Our ref: NO/2012/103956/01-L01
Your ref: 3/2012/0524
Date: 26 July 2012

BANK PROTECTION/STABILISATION WORKS CONSISTING OF ROCK ARMOR WALLS, RIP RAP AND REGRADED BANK AND IMPROVED TEMPORARY CONSTRUCTION ACCESS JUNCTION HOLDEN WWTW, BOLTON BY BOWLAND ROAD, HOLDEN BB7 4NL

We have considered the above proposal and the revised plan Ref: TS928 Proposed Site Plan 03 Rev E and can comment as follows:

**PROPOSED PLAN**  
Scale 1:200

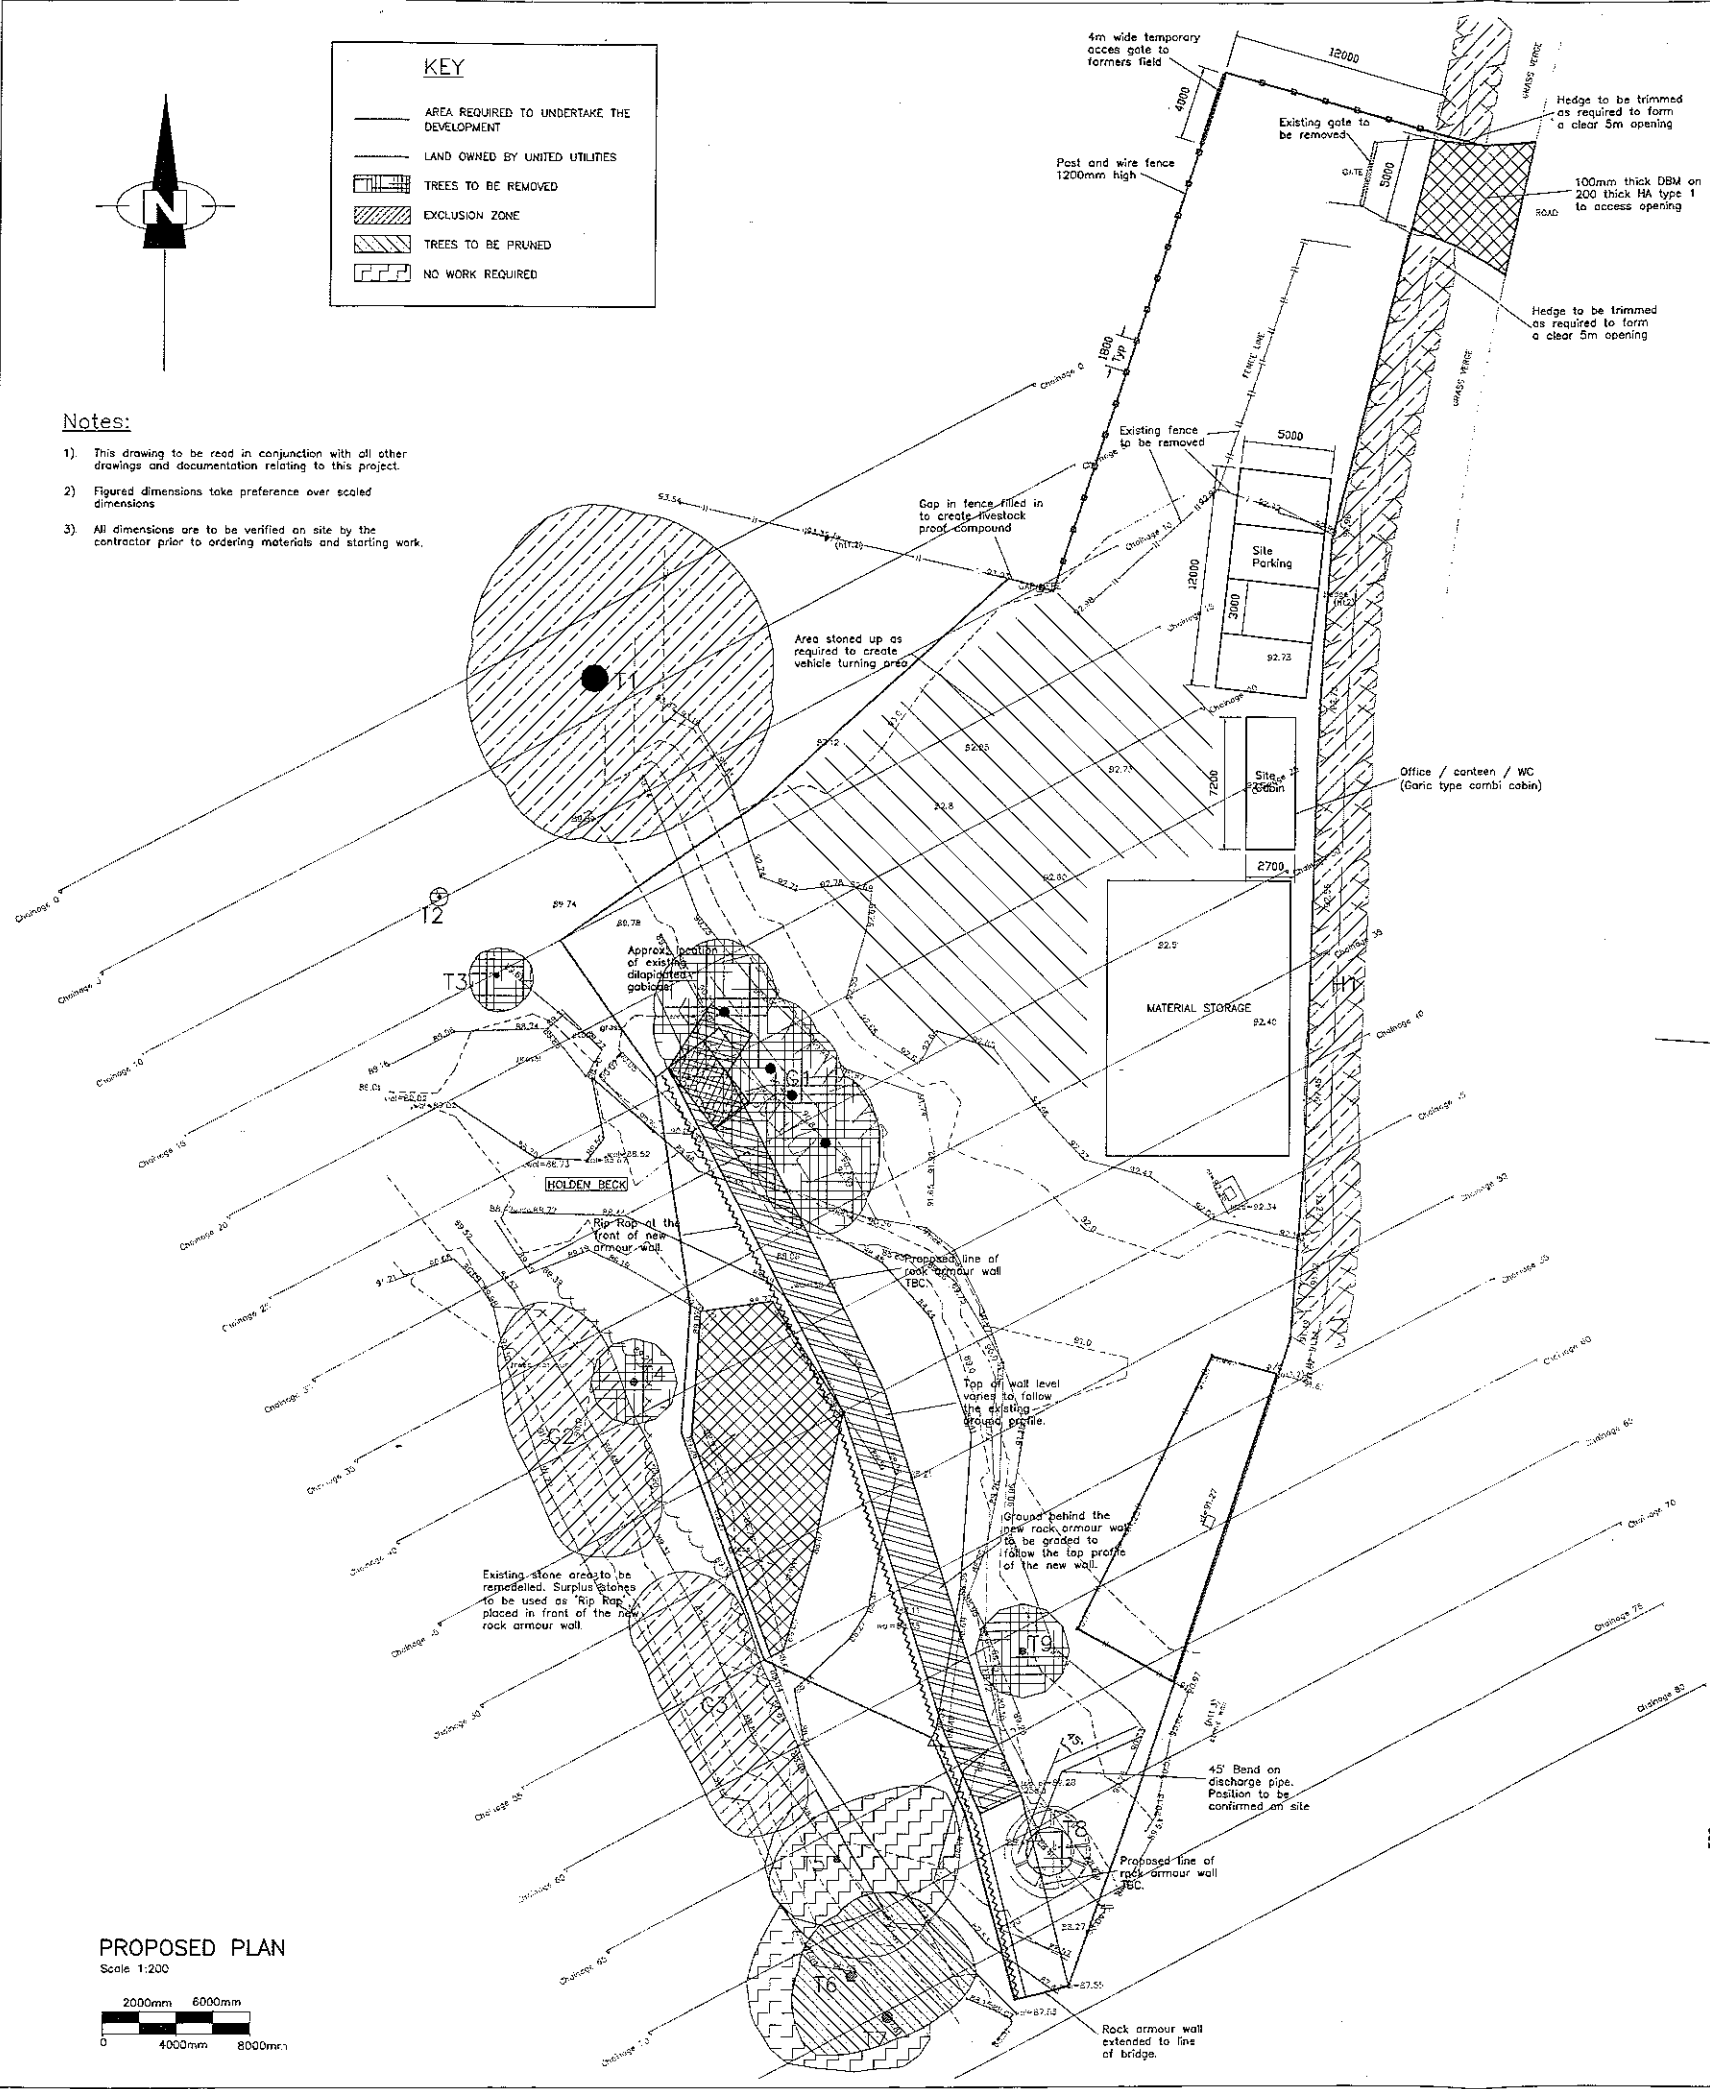
We **object** to the proposed development as submitted because the revised plan Ref: TS928 Proposed Site Plan 03 Rev E (2) and the risk posed to nature conservation are inadequate.

The revised plans submitted with the application are inadequate and do not properly address the risks. In particular, the proposals do not:

Reflect what was agreed on site between ourselves and United Utilities on Wednesday 18th

July 2012. The line of the proposed revetment wall is now not as straight as the original plan but does not follow the curve of the bank as closely as was agreed on site and makes too much of a pinch point against the gravel bar feature.

A revised plan needs to be submitted to the Local Planning Authority, the plan should show the revetment wall following the current alignment of the channel. Furthermore, the annotated comments regarding the remodelling of the stone area need to be removed.

This gravel bar opposite the eroded bank is now to stay in place, with only the top dry section of the bar removed to 6 inches above normal water level. This will allow the potential spawning gravel to stabilize at the tail of the pool and allow peak flows to go over the bar feature.
